DESIGNERS RESPONSE TO STAGE 1 AND 2 RSA

DATE:	31 st May 2023	CONFIDENTIALITY:	Restricted
SUBJECT:	Whitechapel Road PROWs, Cleckheaton– Designers Response		
PROJECT:	PROW, Whitechapel Road, Cleckheaton	AUTHOR:	N Smith
CHECKED:	D Bowker	APPROVED:	D Bowker

Report Title:	Whitechapel Road PROWs, Cleckheaton– Designers Response	
Date:	31/05/2023	
Document reference and revision:	H8040-004_Document – Engineering_AFU_._ PROW Combined Stage 1 and 2 Road Safety Audit Phase 2– Designers Response _P01	P01
Prepared by:	N Smith	
On behalf of:	BDW Homes, West Yorkshire

| TITLE:   | S38 PHASE 2<br>PROPOSED SURFACE FINISHES & KERBING<br>SHEET 2 OF 2 |

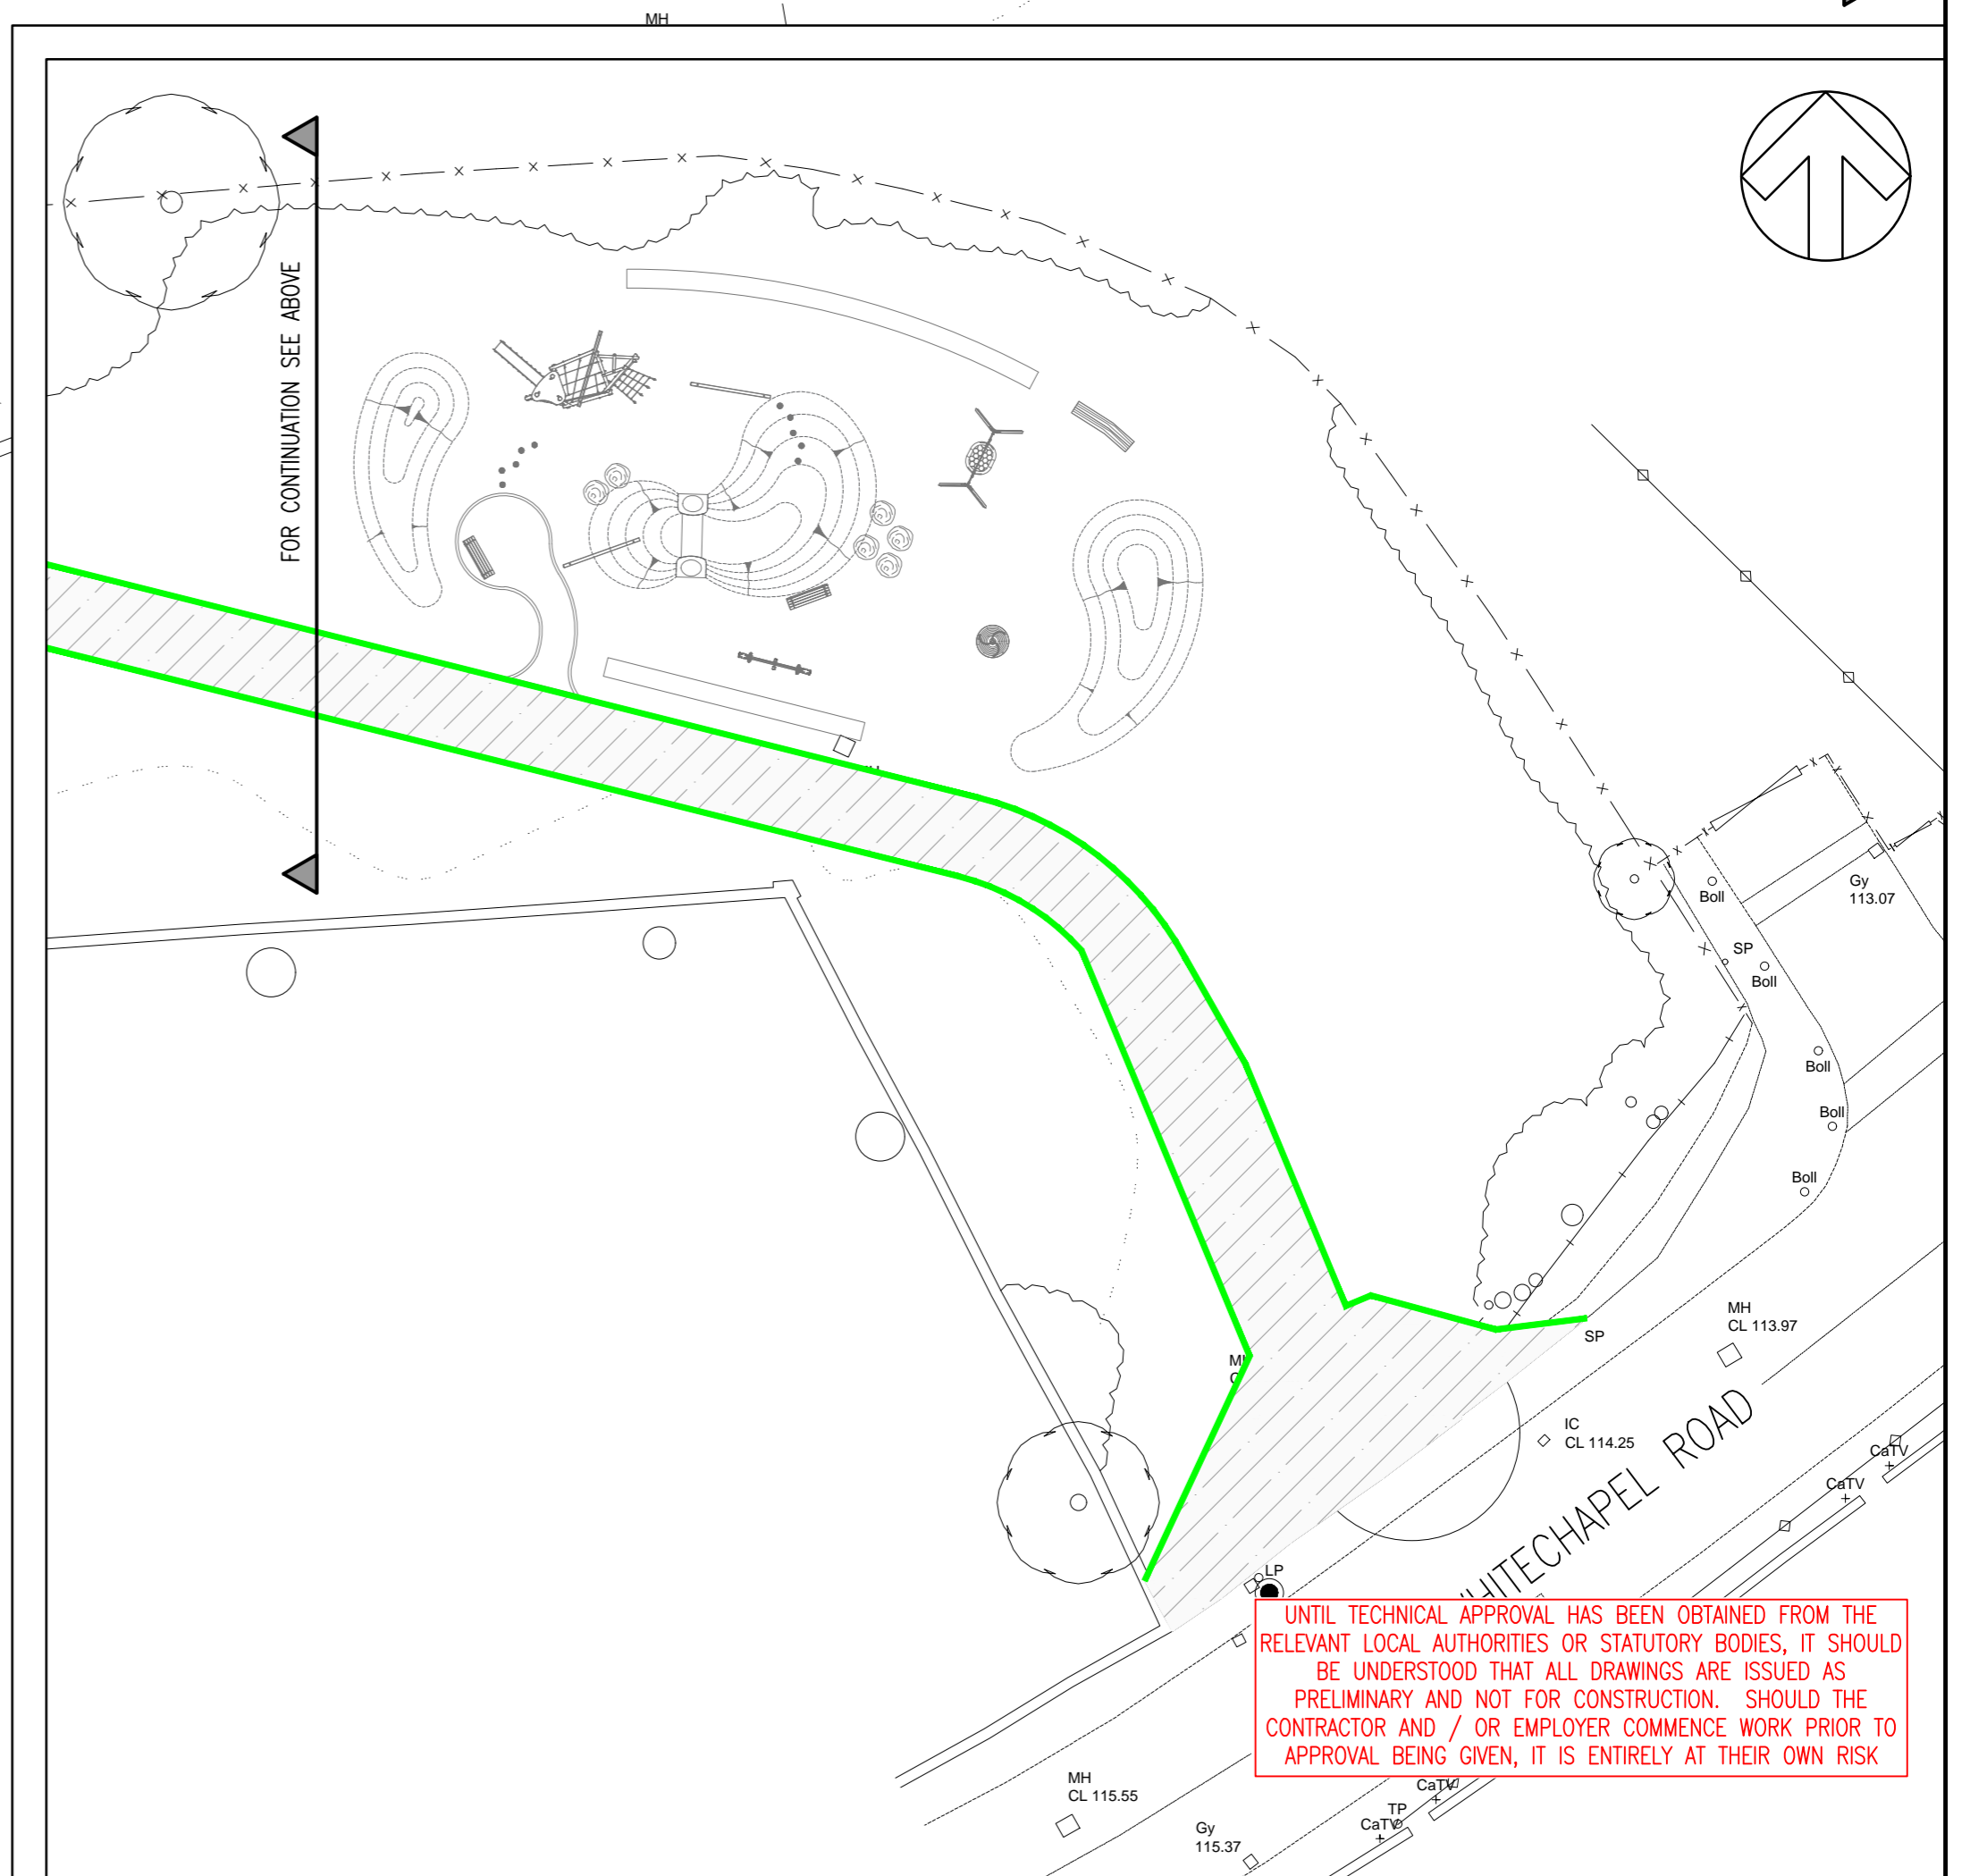
The proposals indicate that part of the diverted PROW will cross Road 1 in the vicinity of plot 111. This uses the vehicle crossover to the drive to plot 111 and there is no dropped kerb or tactile paving on the opposite footway. Failure to indicate a safe crossing point for pedestrians could lead them to use less safe locations.

The drawings indicate that part of the diverted PROW will cross Road 1 in the vicinity of plot 111 using the vehicle crossover to its driveway. The Audit Team has noted that there is no dropped kerb or tactile paving on the opposite footway in this location.

Whilst the potential for a crossing pedestrian being in conflict with a vehicle using the driveway to plot 111 is small, the location is not ideal and would make it difficult to provide tactile paving in that location. The lack of a dropped crossing and tactile paving on the opposite footway would result in people in wheelchairs or with perambulators

having to bump over full height kerbing.

Failure to indicate a safe crossing point for pedestrians could lead them to use less safe locations.

It is recommended that the design team review the location of this crossing point and place it away from driveways so as to allow the provision of dropped crossings and tactile paving.

The crossing point has been moved slightly north on Road 1 so that it does not conflict with proposed driveway entrances.

The crossing point is now specified with a tactile paved dropped crossing on either side of the road people in wheelchairs or with perambulators.

The design of the proposed ramp does not fully address usage by vulnerable users with mobility difficulties. There are no measures proposed for aiding people with vision or mobility deficiencies. These issues could result in potential injuries to such users.

The design of the proposed ramp has gradients of 1 in 15 between platforms of 1.2m in length and will be 2m wide. The proposed alignment will place users some 1.8 – 2.0m above the proposed levels of the adjacent highway on a sharp bend in the ramp with no indication to people with vision deficiencies of a safe edge / boundary to follow or provision of hand rails or edge restraints / boundary treatments.

The proposed landings also appear to be quite short particularly for those in wheelchairs or pushing perambulators.

It is recommended that the ramp design be reviewed against current good practice guidance and drawings be amended to provide people with vision deficiencies guidance in its use and route and protection from the level difference and adequate landing lengths for wheelchair users and those with perambulators

The design has been revised to include a handrail on the ramped (1:15) section of the PROW to assist people with vision deficiencies. Tactile pavers at the exit to the ramp have now been included to direct users to the formal crossing point on Road 1.

It has not been possible to provide a ramp with increased platform widths or reduced gradients due to the space and alignment constraints on the route. The 1:15 gradient was agreed with the PROW Officer.

REVISION			
DRAWING TITLE			
PROW FINISHES PLAN			
PROJECT:			
RESIDENTIAL DEVELOPMENT			
PROJECT ADDRESS:			
WHITECHAPEL ROAD CLECKHEATON			
DRAWN	SCALE	DATE	
AJC	1:250 @ A0	NOV 2021	
DATE	DWG. NO.	REVISION

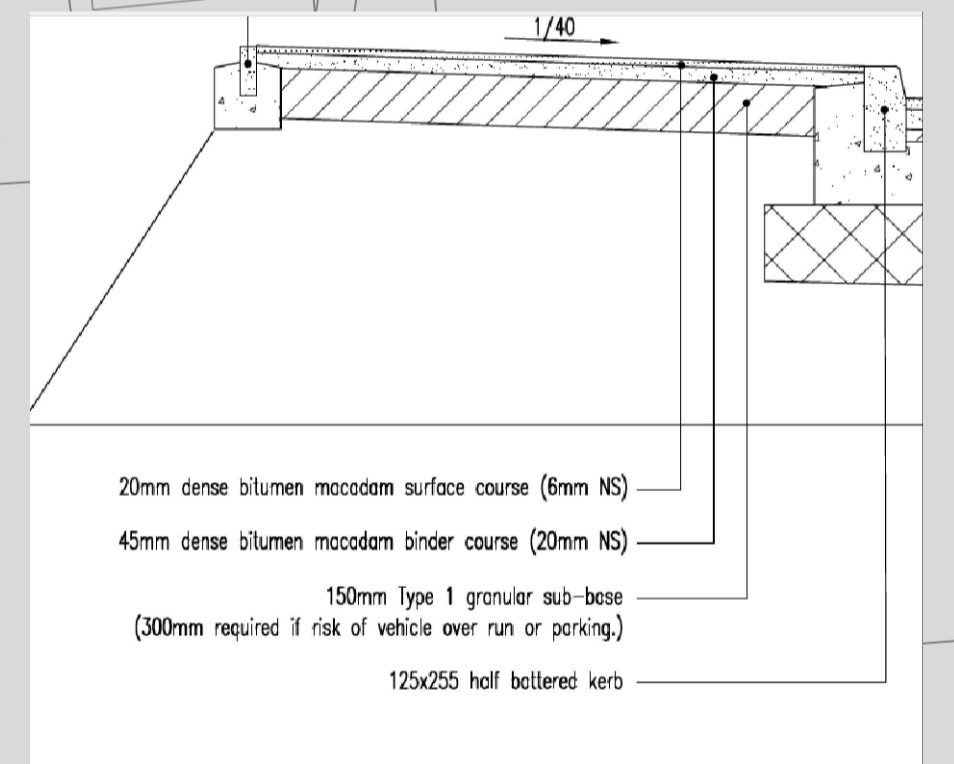
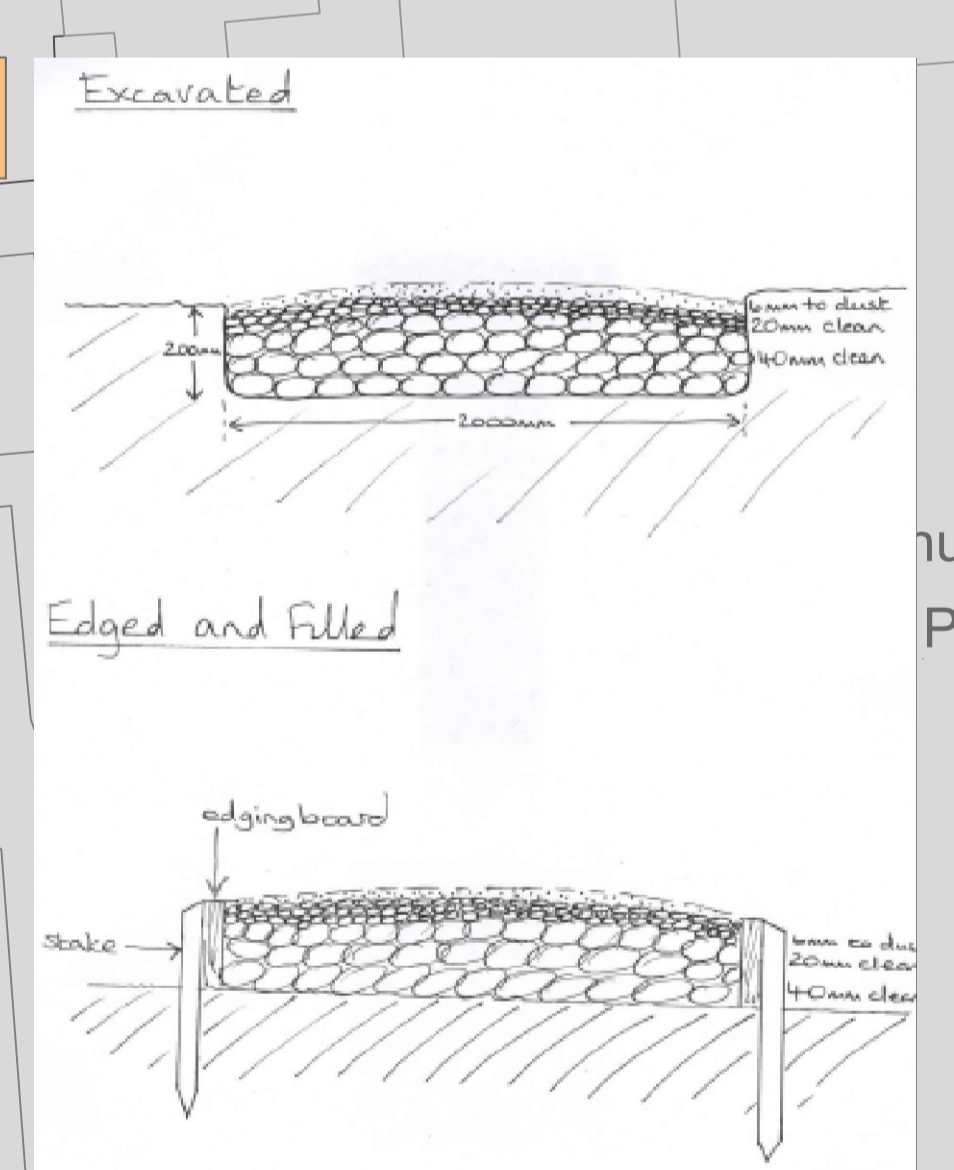
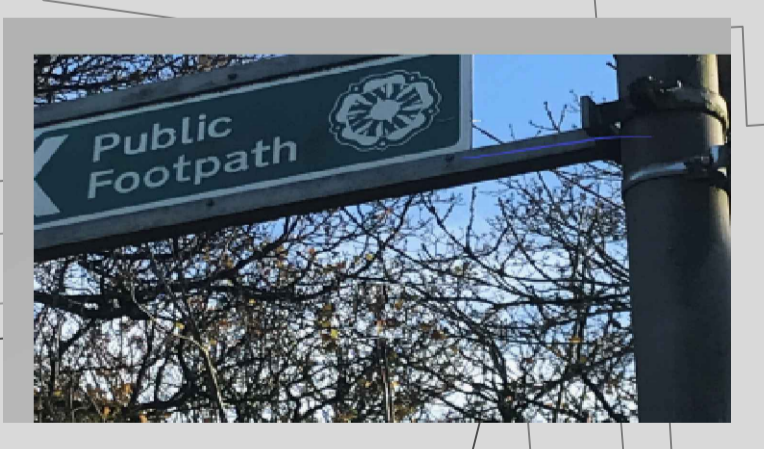
The drawings do not show whether the PROW signage is single or double sided.

The drawings do not show whether the PROW signage proposed will be single or double sided in the different locations and so routes may not be clear to all users and take alternative and perhaps less safe routes.

1. To show whether they are single or double sided as the need arises for each location.
2. The designated crossing points where PROW users cross the new estate roads be sign posted / clearly marked and / or warning signage provided as necessary.

Requirement for all PROW signs to be double sided now indicated on design drawings.
